SUBMISSIONS REPORT

**INSTITUTE OF APPLIED
TECHNOLOGY FOR
CONSTRUCTION**

TAFE NSW

This Submissions Report has been prepared by Urbis on behalf of Technical and Further Education (**TAFE**) NSW in respect of the State Significant Development (**SSD**) application (SSD-8571481) for an educational facility at 2-44 O'Connell Street, Kingswood (**the project**).

DWG #	DA0110	REV	D
SCALE @ A1	As indicated

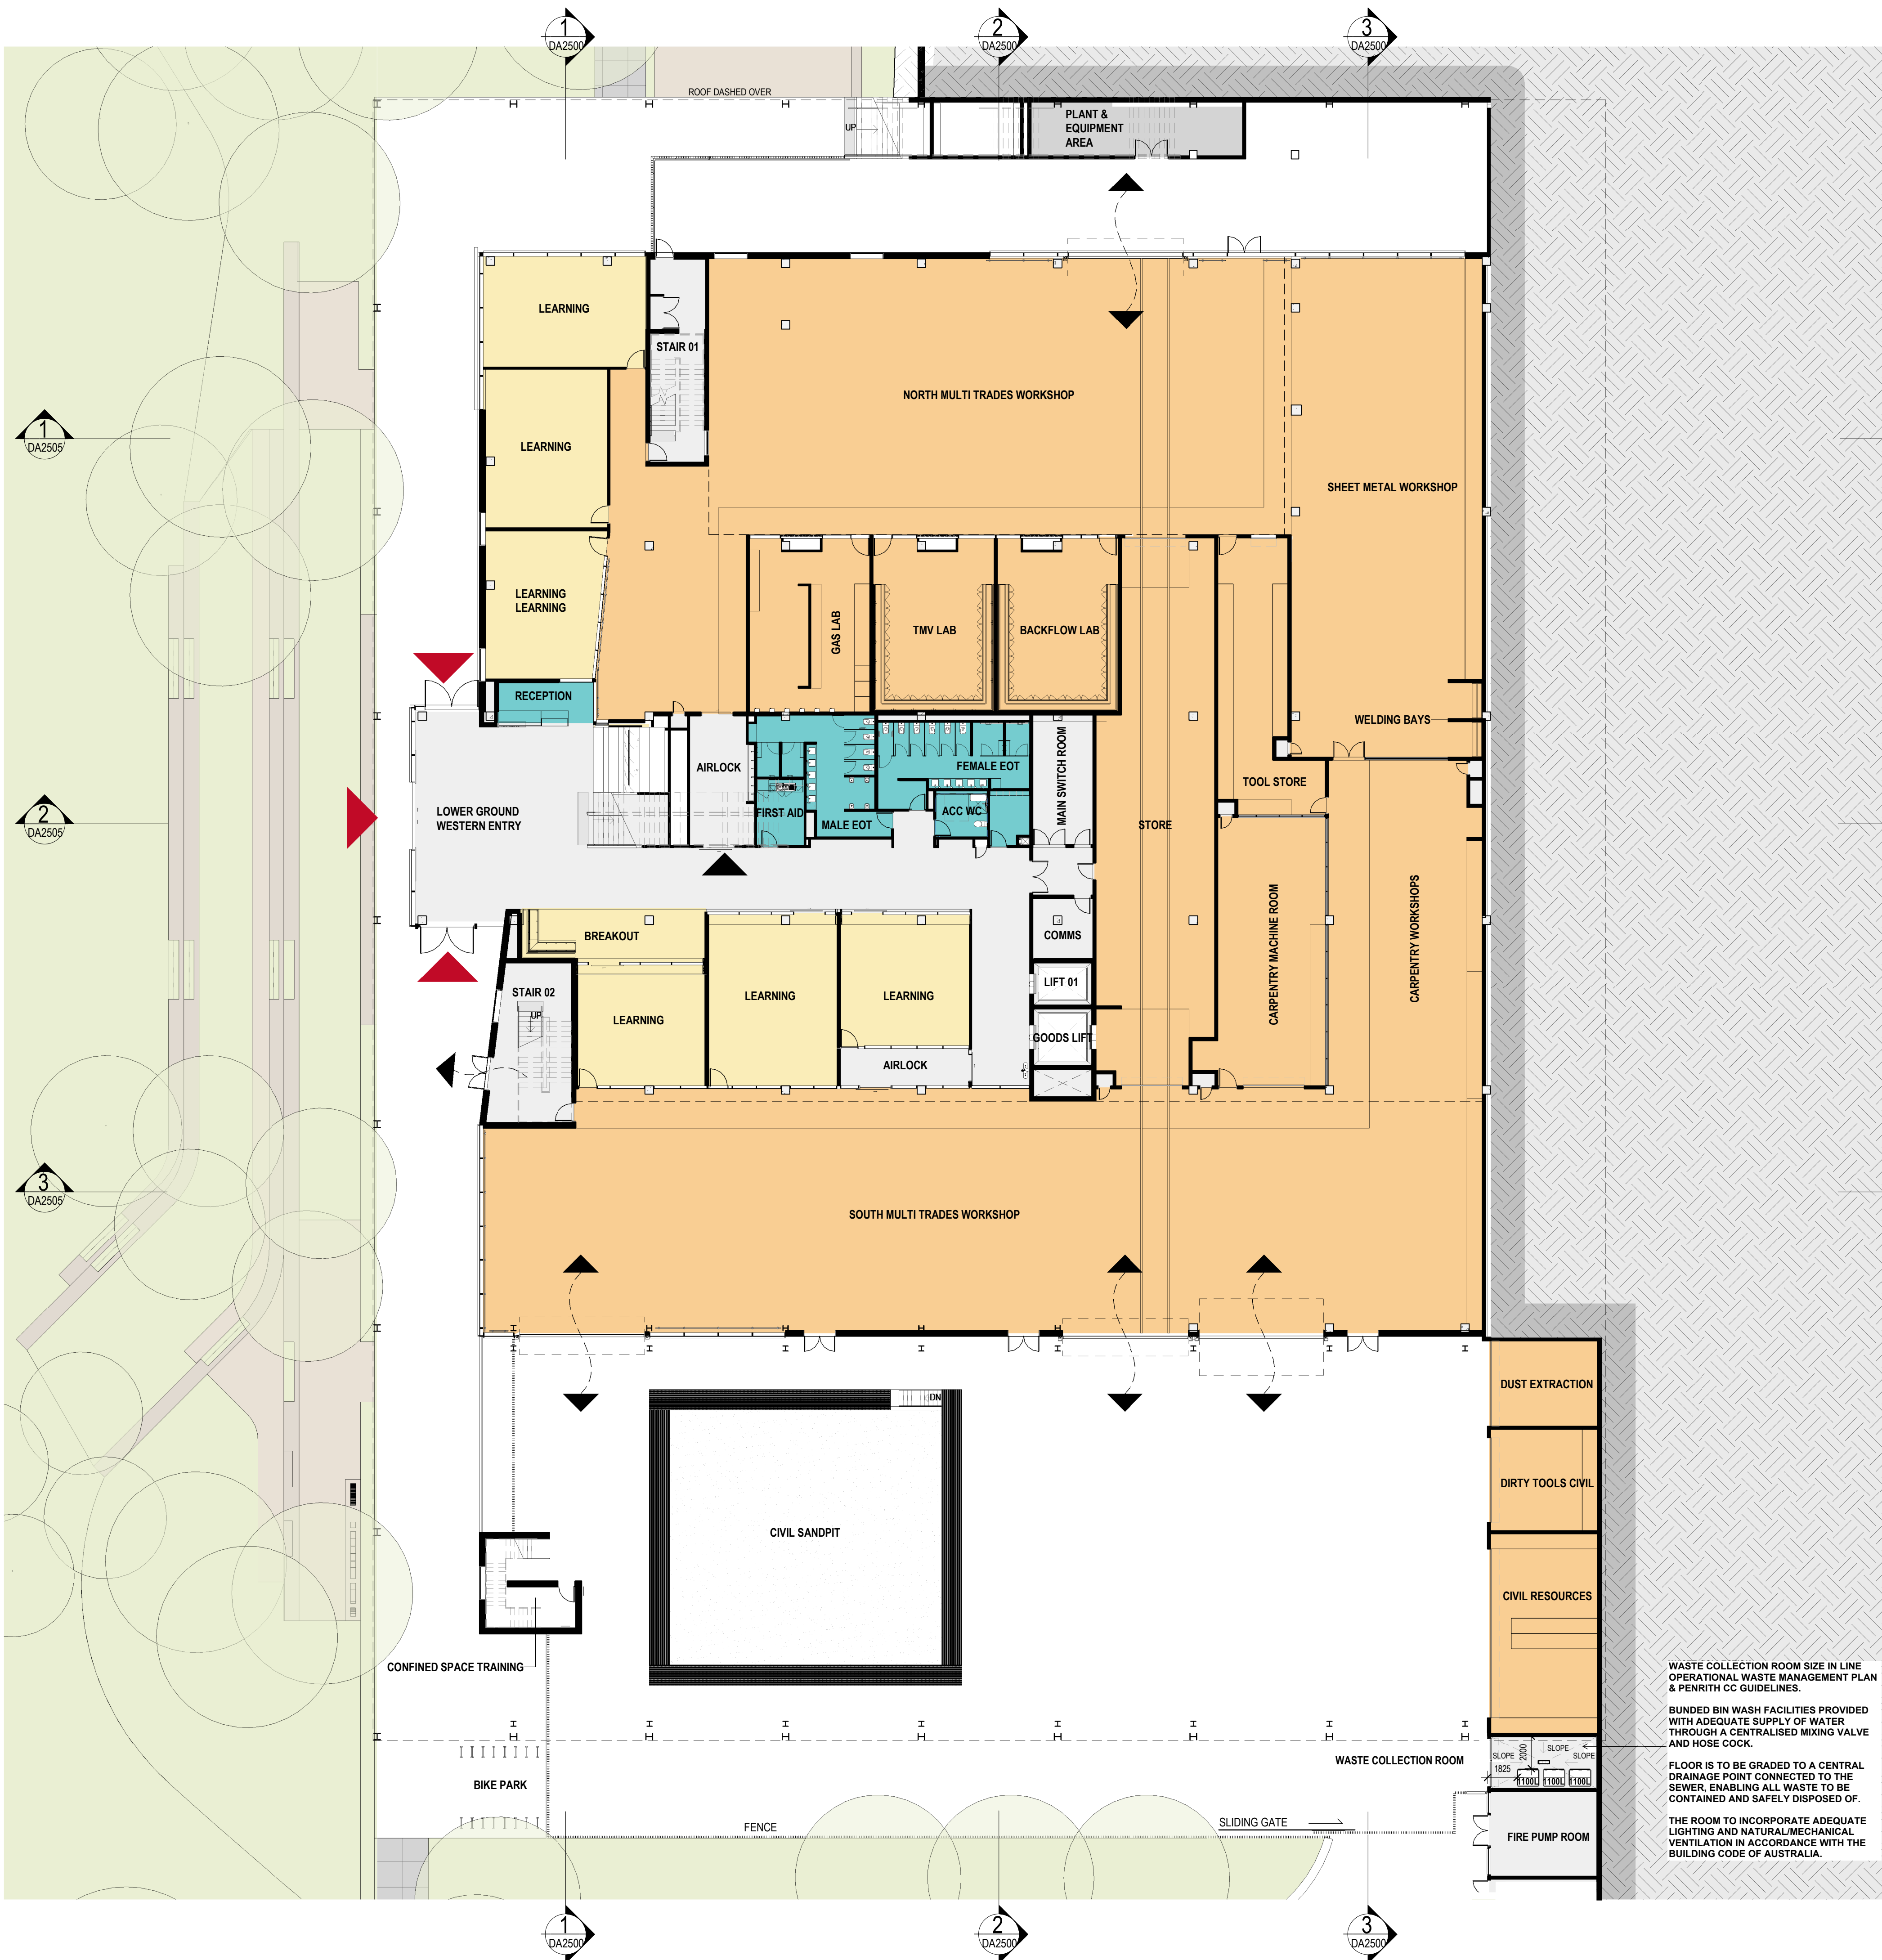
Issue	Referral comment	Response to submission	Reference to information
	<ul style="list-style-type: none"> - modelling of the GWH / Western Sydney University intersection, demonstrating the results of the intersection performance during each stage of construction work. - additional evidence to demonstrate that the swept paths of construction vehicles can be achieved without crossing the centreline of O'Connell Street and other internal roads. 	<p>Modelling of the GWH / Western Sydney University intersection is provided in the Preliminary Construction Traffic and Pedestrian Management Plan (CTPMP) (Appendix J). The analysis demonstrates performance of this intersection during the construction period will not reduce the level of service or cause an increase to the level of delay.</p> <p>Construction vehicles will not utilise the Gate 2 access on O'Connell Street. Rather, access for construction vehicles is provided through the adjacent WSU site, via a signalised turn off on Great Western Highway. Notwithstanding this, updated swept path analysis has been appended to the Transport and Accessibility Impact Statement (Appendix H). This analysis demonstrates the largest vehicle requiring access to the site does not cross the centreline of O'Connell St.</p>

DWG #	DA5000	REV	E
SCALE @ A1	1 : 500

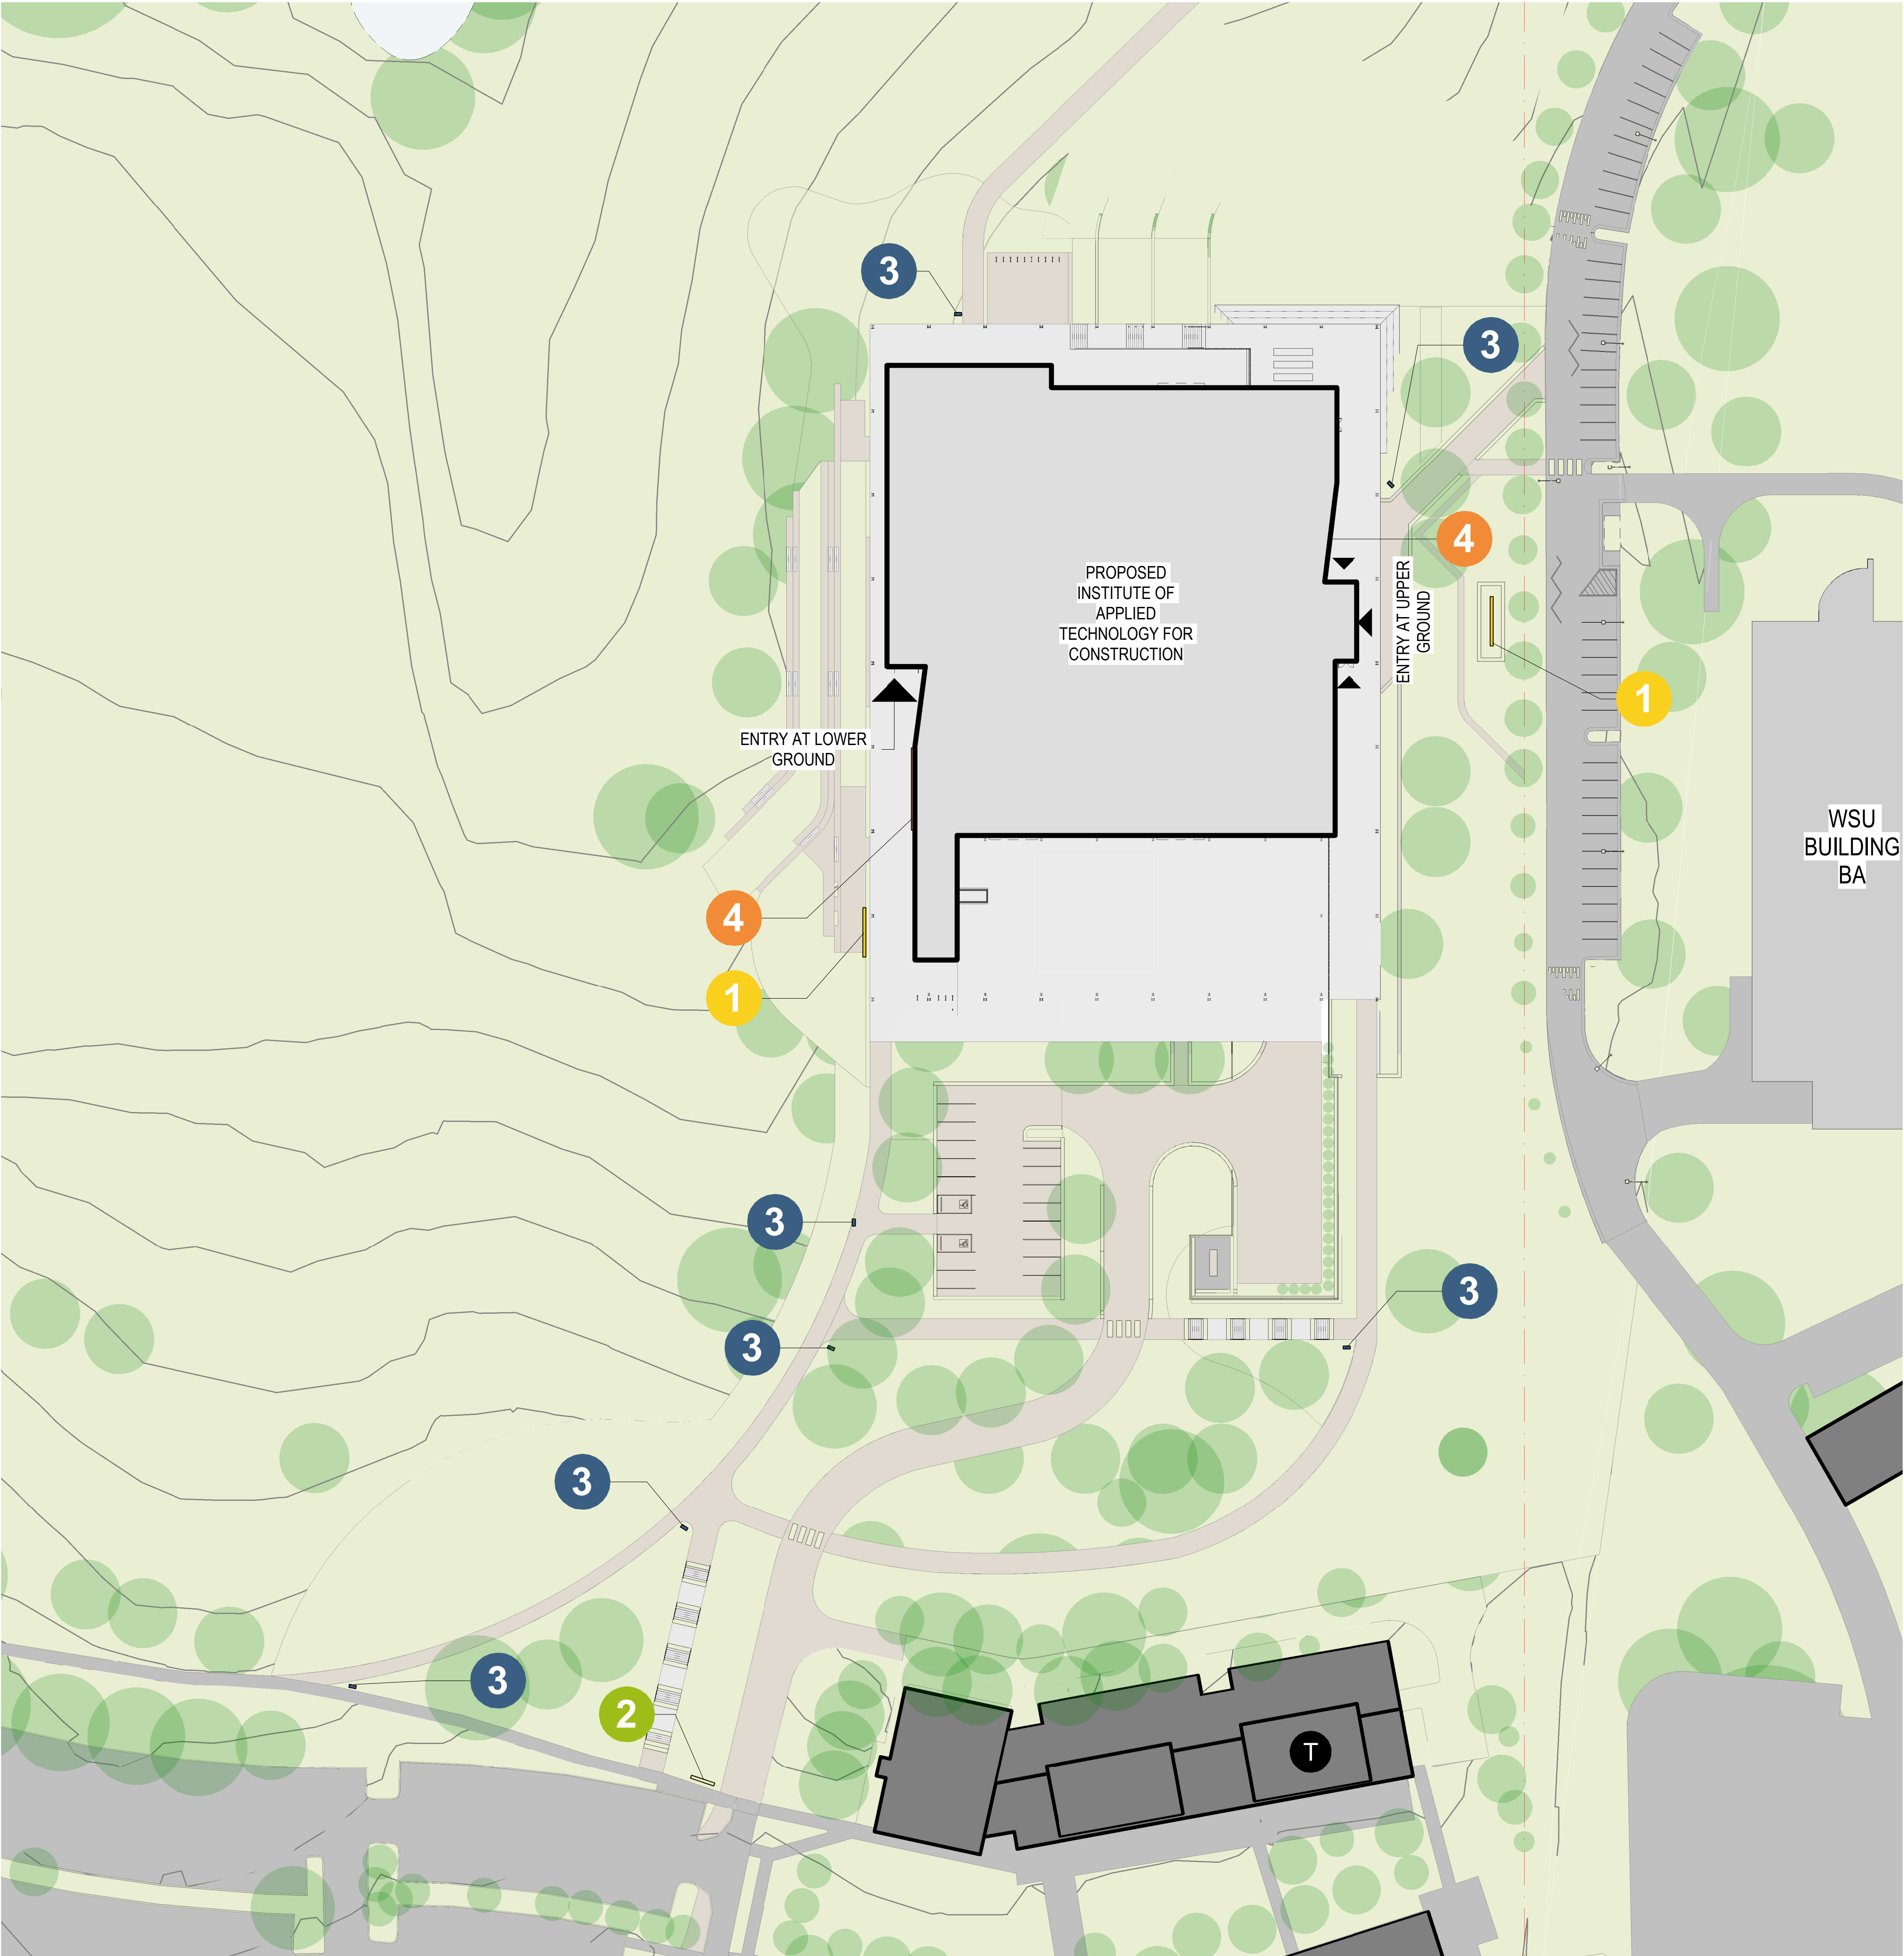
<p>8. Waste Management</p>	<p>All developments are required to provide a waste collection room integrated wholly within the built form to permit a safe and efficient waste collection service. The room will need to incorporate infrastructure into its design in accordance with section 3.4 of the ‘Industrial, commercial and mixed-use waste management guideline’ document. At present this has not been included in the development. The plans should be revised to provide for this integrated infrastructure and address the Council’s Penrith DCP 2014 – Waste Guideline.</p>	<p>A nominated waste collection room has been provided on the southern elevation of the building, adjacent to the vehicular loading bay. The waste collection room has an approximate area of 16sqm, which satisfies the spatial requirements of 13.6sqm as identified in the Waste Management Plan prepared by Waste Audit and submitted within the SSDA package.</p> <p>This is consistent with Section 5.3.4 of the Penrith DCP 2014 as follows:</p> <ul style="list-style-type: none"> - Waste collection can occur in the adjacent loading area. As identified in the swept paths provided in the Transport and Accessibility Impact Assessment (Appendix H), vehicles can enter and exit the loading area via forward direction with only one reverse entry manoeuvre required. 	<p>Amended Architectural Plans (Appendix C)</p>

Issue	Referral comment	Response to submission	Reference to information
		<ul style="list-style-type: none"> - The waste storage area will be concealed by the adjacent sliding gate and services area. - Access to adequate hot and cold-water supply is available for washing purposes. - Signposting will be incorporated during detailed design. 	
Environment, Ecology and Science (EES)
